Your Ref: OWPC15657
Our Ref: FG/135/17/PL 18-08-2017
Please ask for:
Mrs A Gardner

Erection of 1 no. 2 bed dwelling
South Point Beehive Lane Ferring

Proposed Block Site Plan - 1:200 @ A1

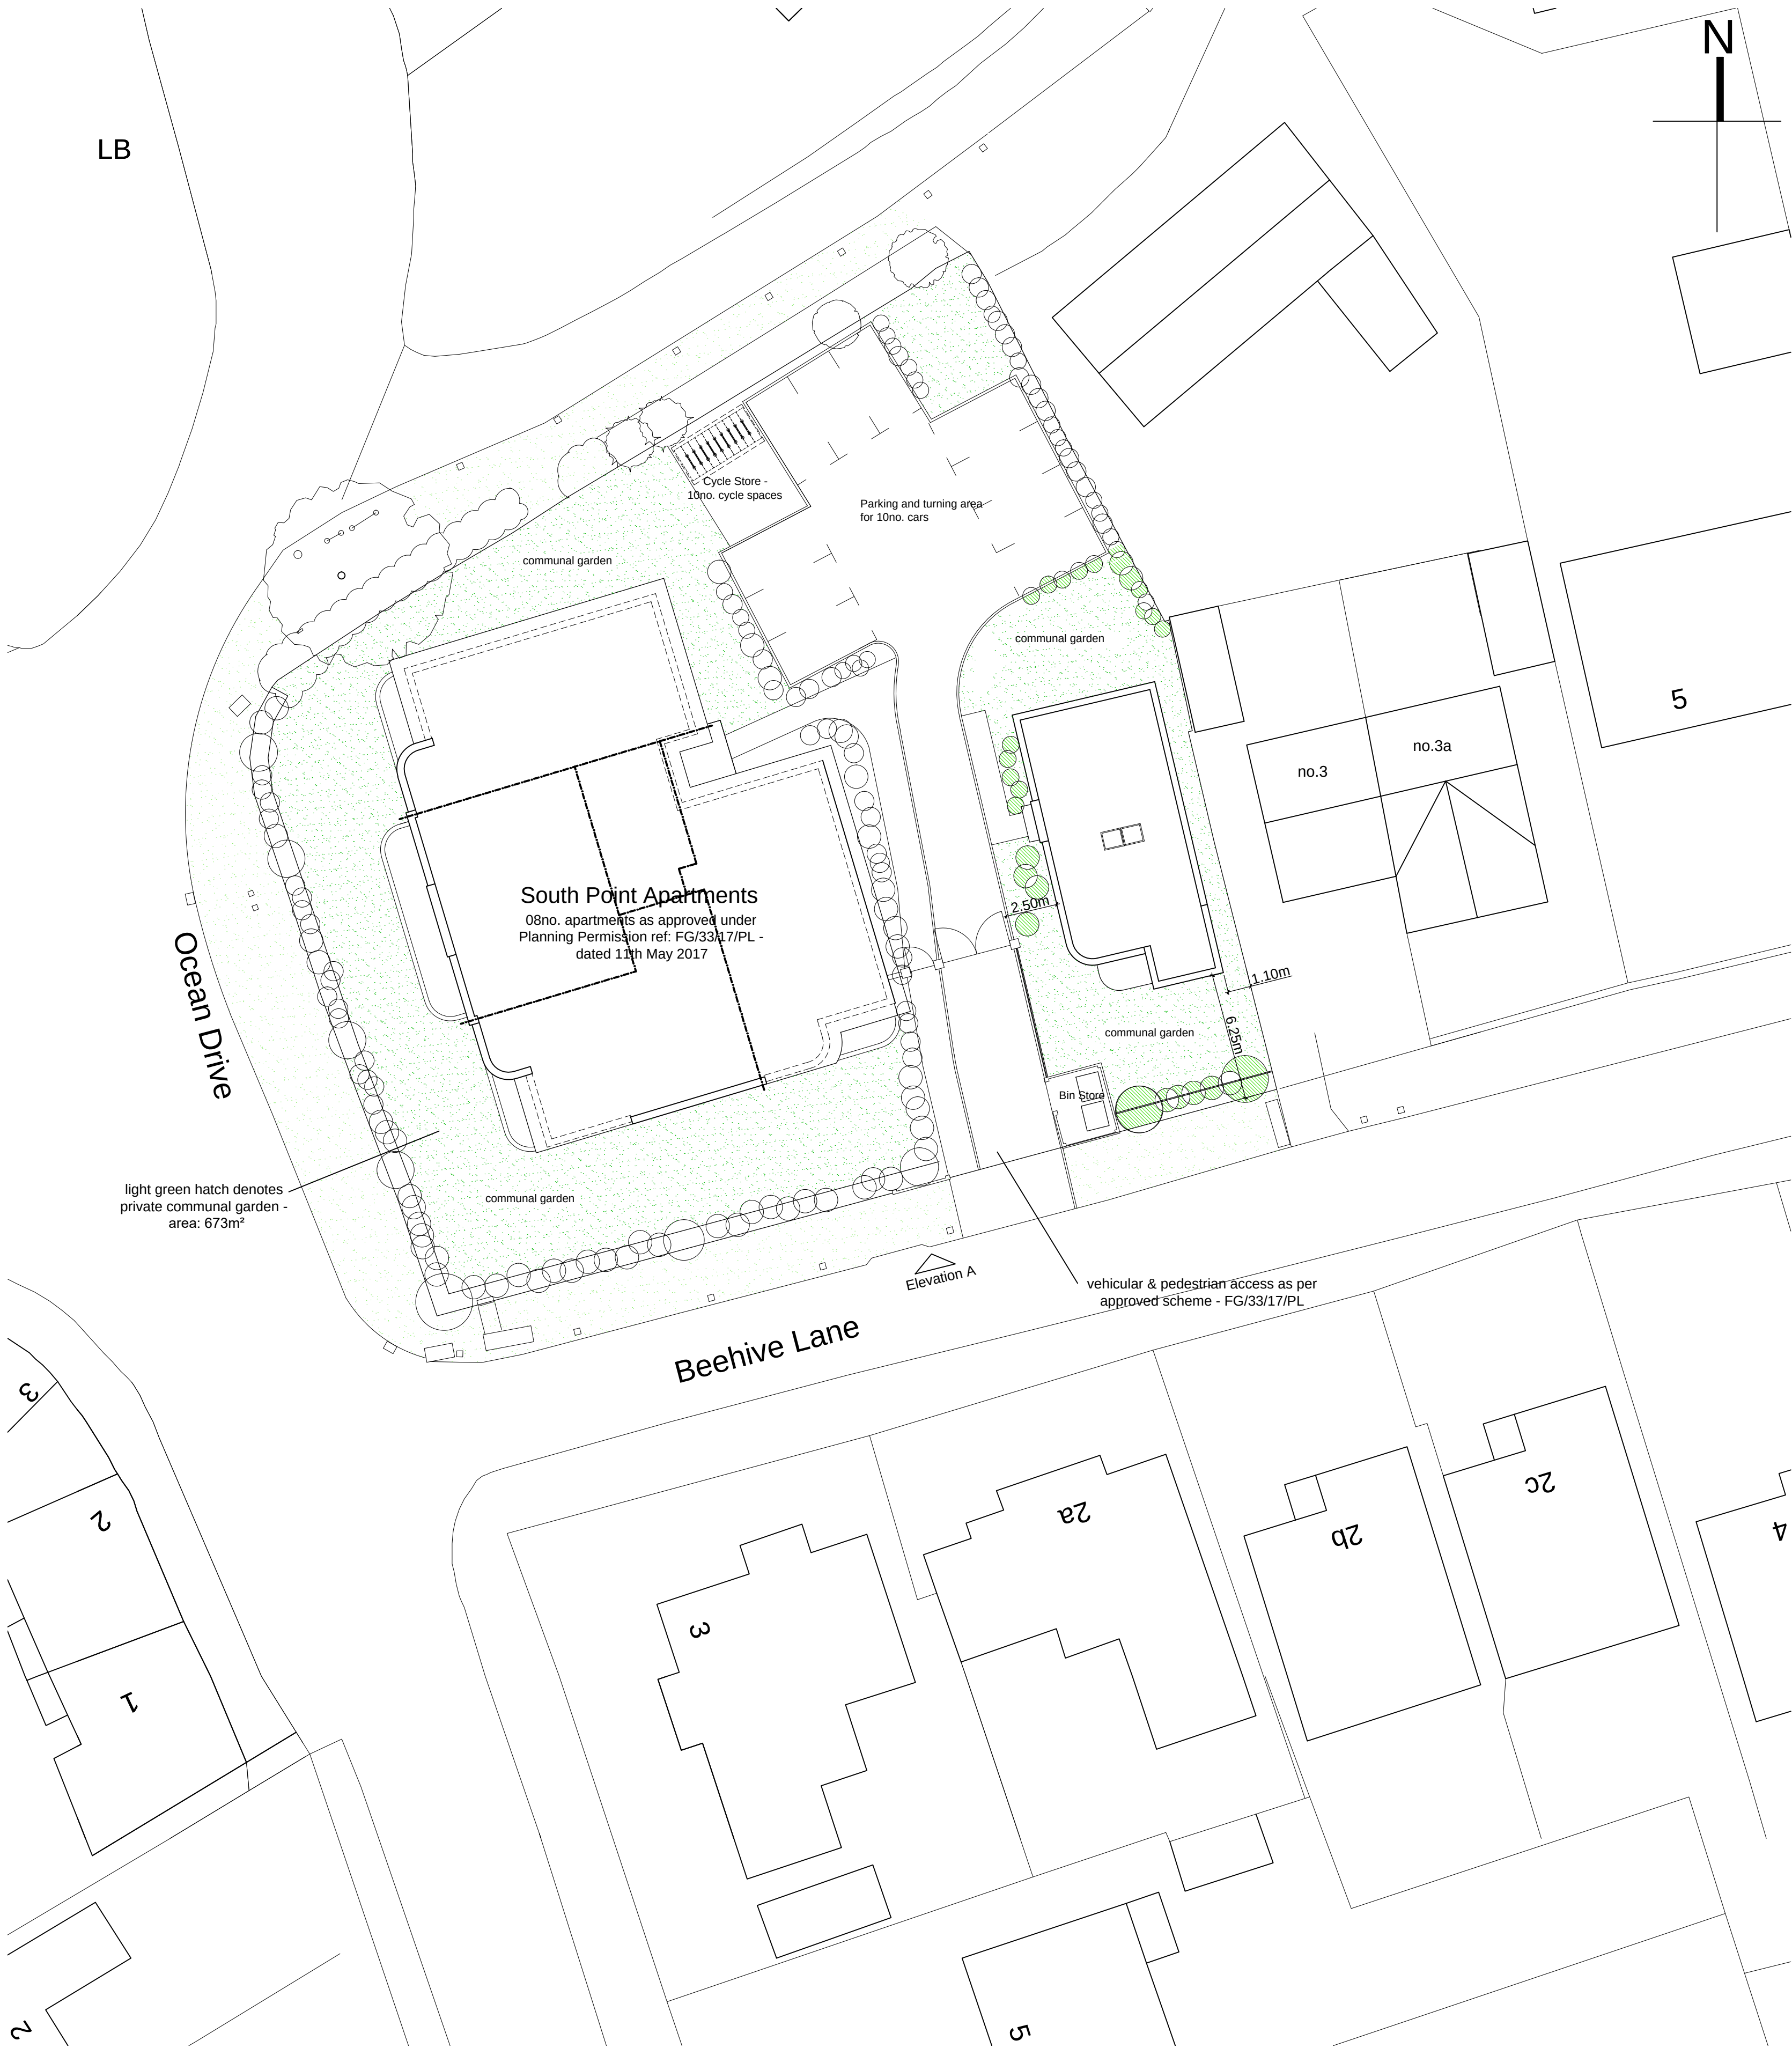
I object strongly to this application for another apartment to be built on the development. The original planning permission was granted on the basis of the landscaped area which would be lost if this further application is agreed. This would certainly constitute overdevelopment & impact greatly on the already long suffering residents in the area most of who did not want this development at all.
